CITY OF ALBUQUERQUE

**RE: Westgate Community Center
10001 DeVargas Rd SW
Grading and Drainage Plan
Engineer's Stamp Date: 9/3/19
Hydrology File: M09D030**

Based on the submittal received on 9/3/19, the Grading and Drainage Plan cannot be approved until the following corrections are made:

DRAINAGE MANAGEMENT PLAN

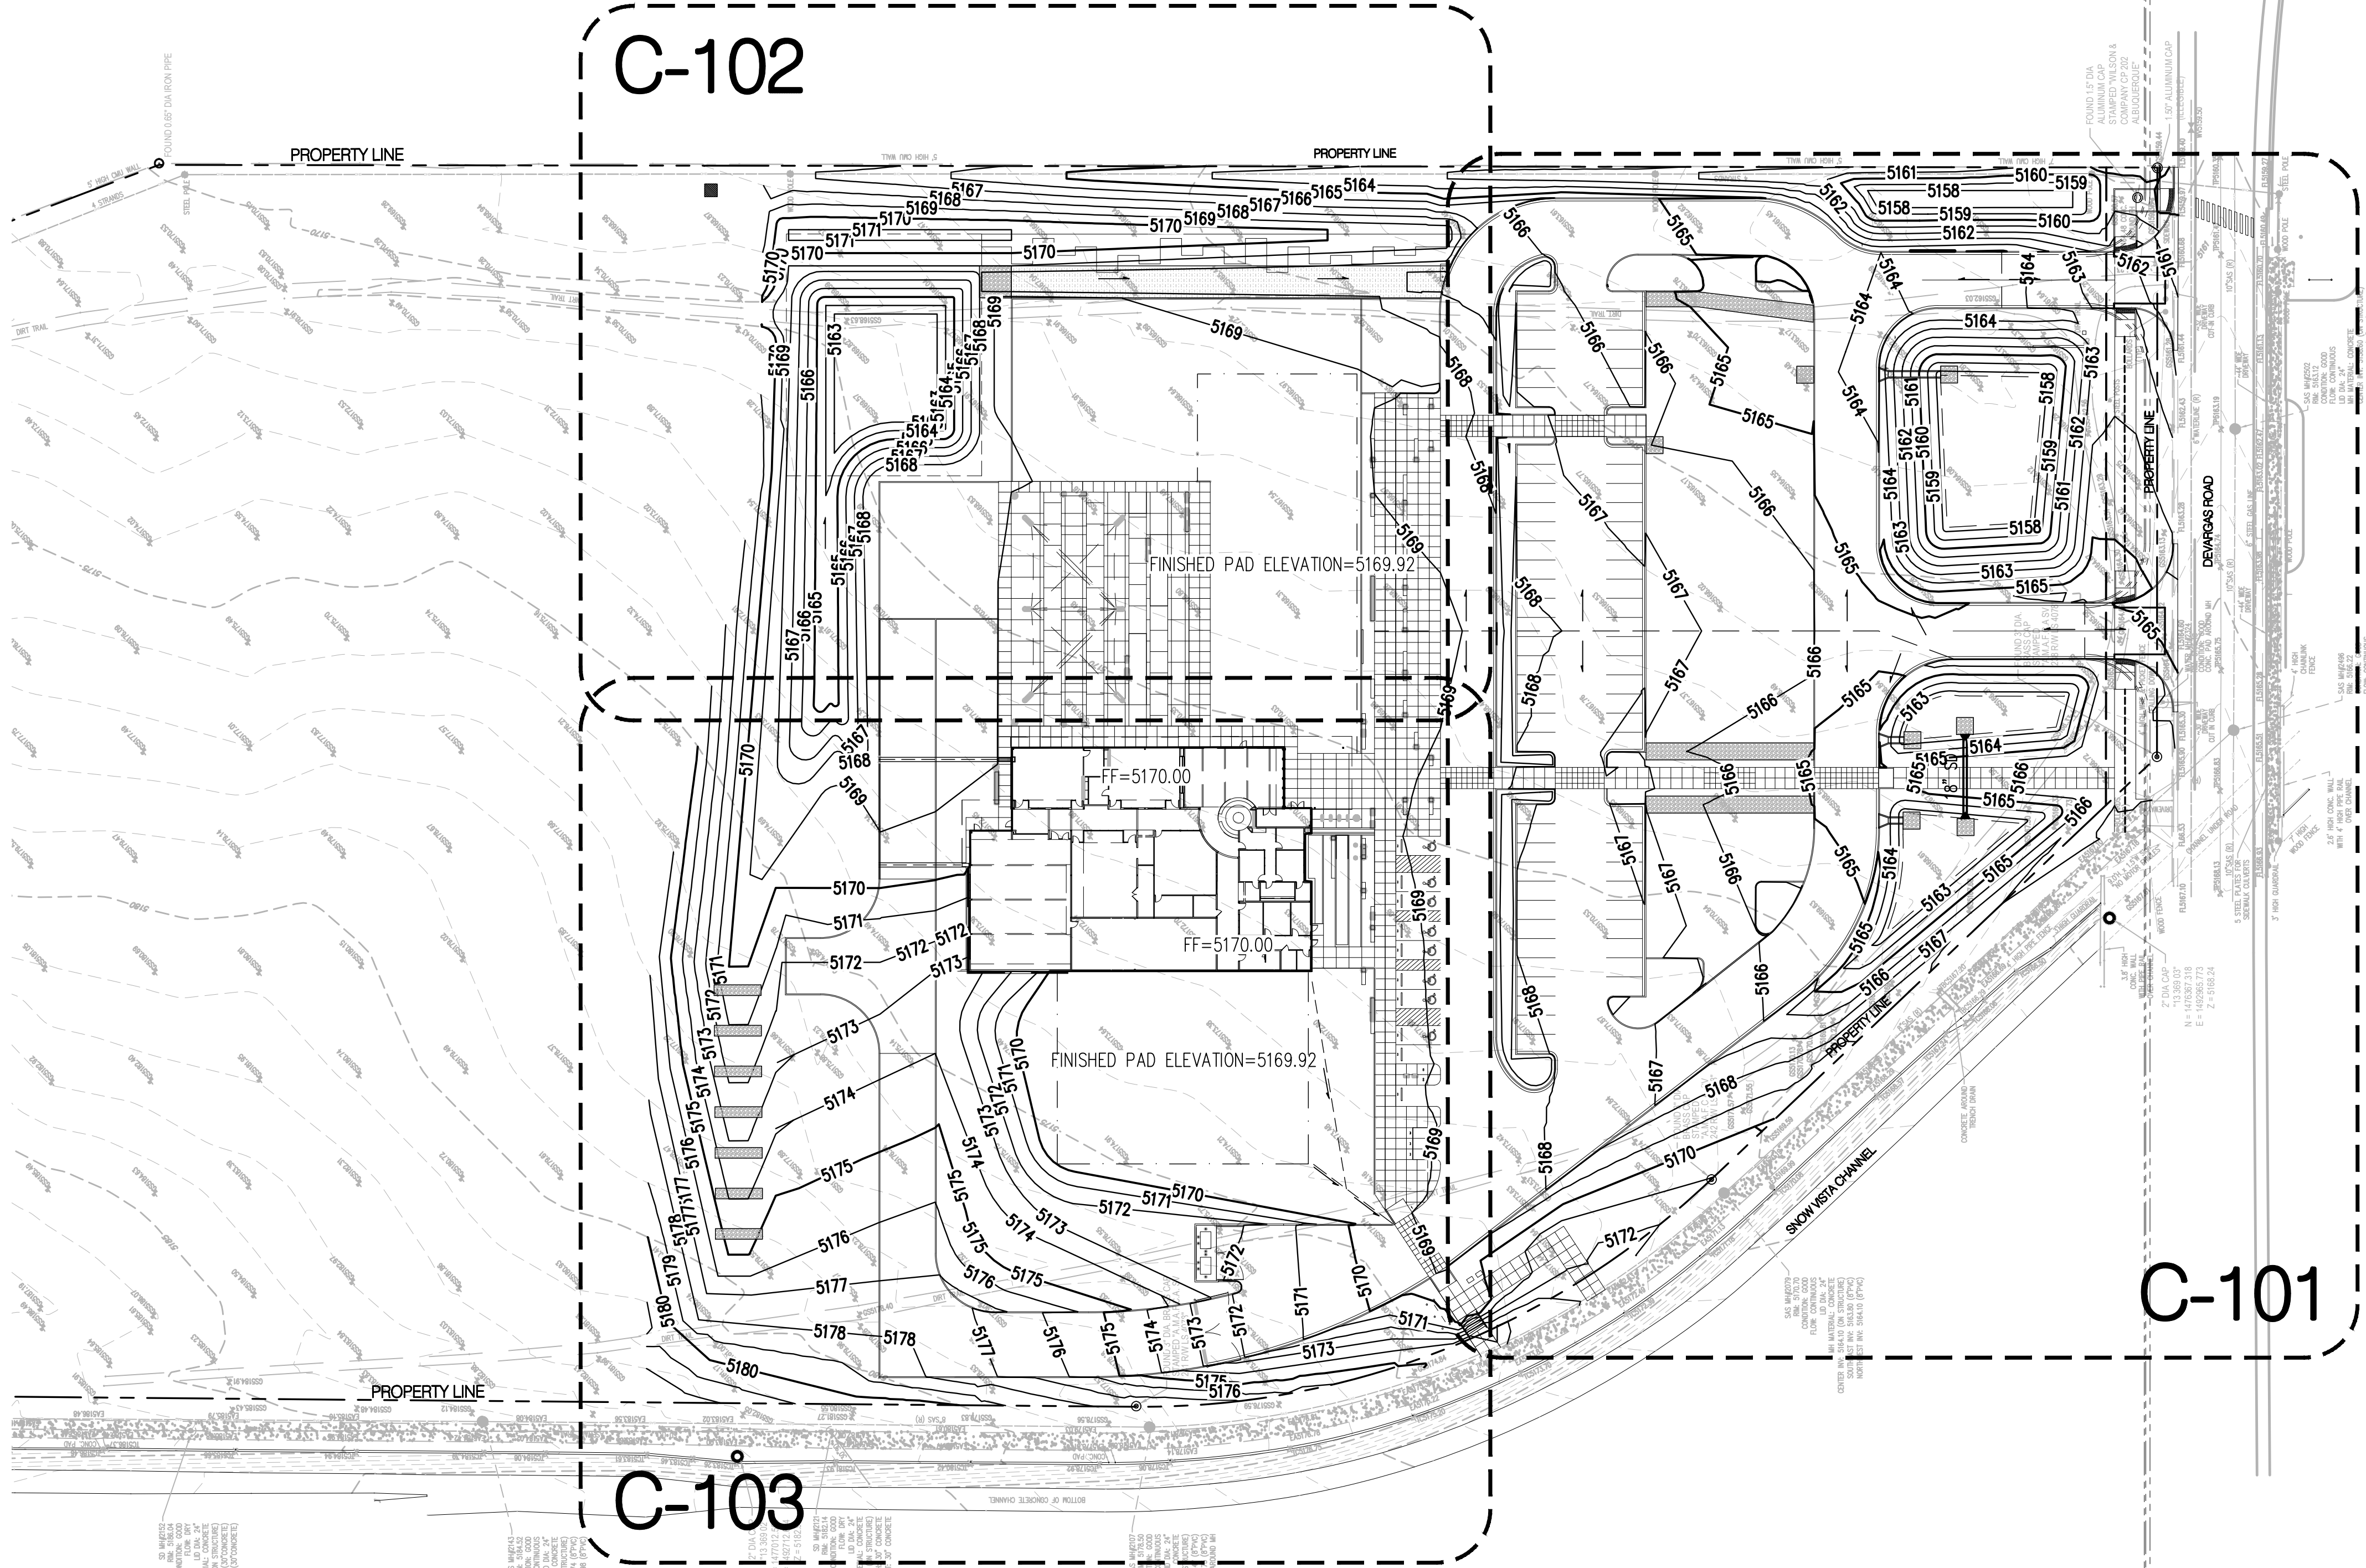
1. Provide an armored emergency overflow from Pond 1; it does not need to be concrete, but it does need to be designed and shown on the stamped grading plan, not the landscaping plan. SW2 is shown in section B-B as a 15' wide swale with unknown depth, but the manning's calculation shows a top width of 45' and a (flow?) depth of 1.63'. The hydraulic calculations must match the section to be constructed. Flow depth needs to be determined in the channel and adequate freeboard provided. Spillway flow depth needs to be determined via the weir equation and adequate freeboard provided along the south and east sides of the pond. Future buildings need to be considered in this design.

G CHECK DAM
NOT TO SCALE

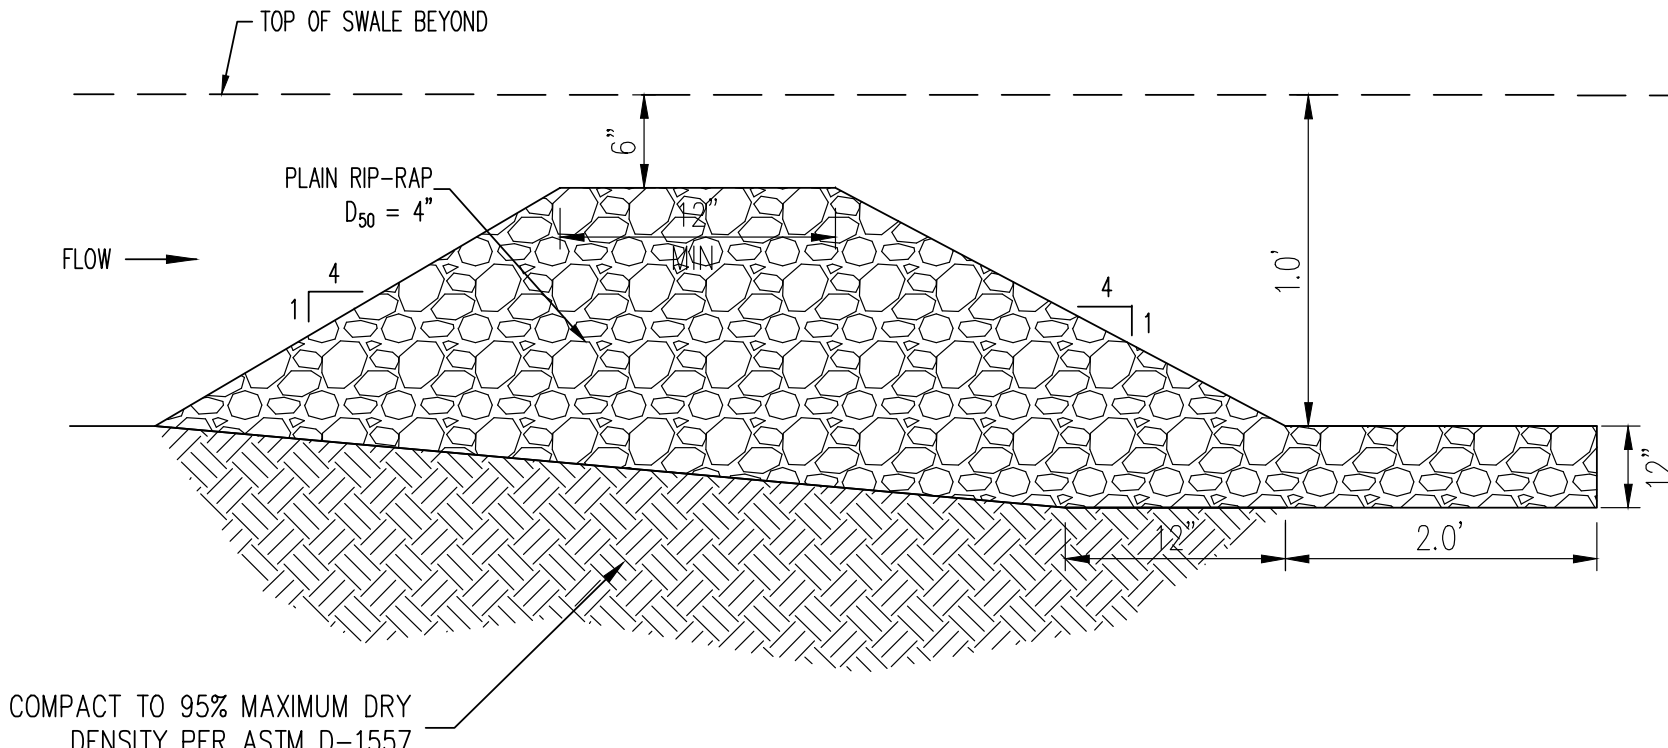
2. Check dams need to be sized and spaced such that the toe of the upstream dam equals the crest of the next downstream dam and provide a sag at midpoint. See NMDOT standards and specifications for temporary erosion and sediment control measures for more details and design standards regarding check dams.
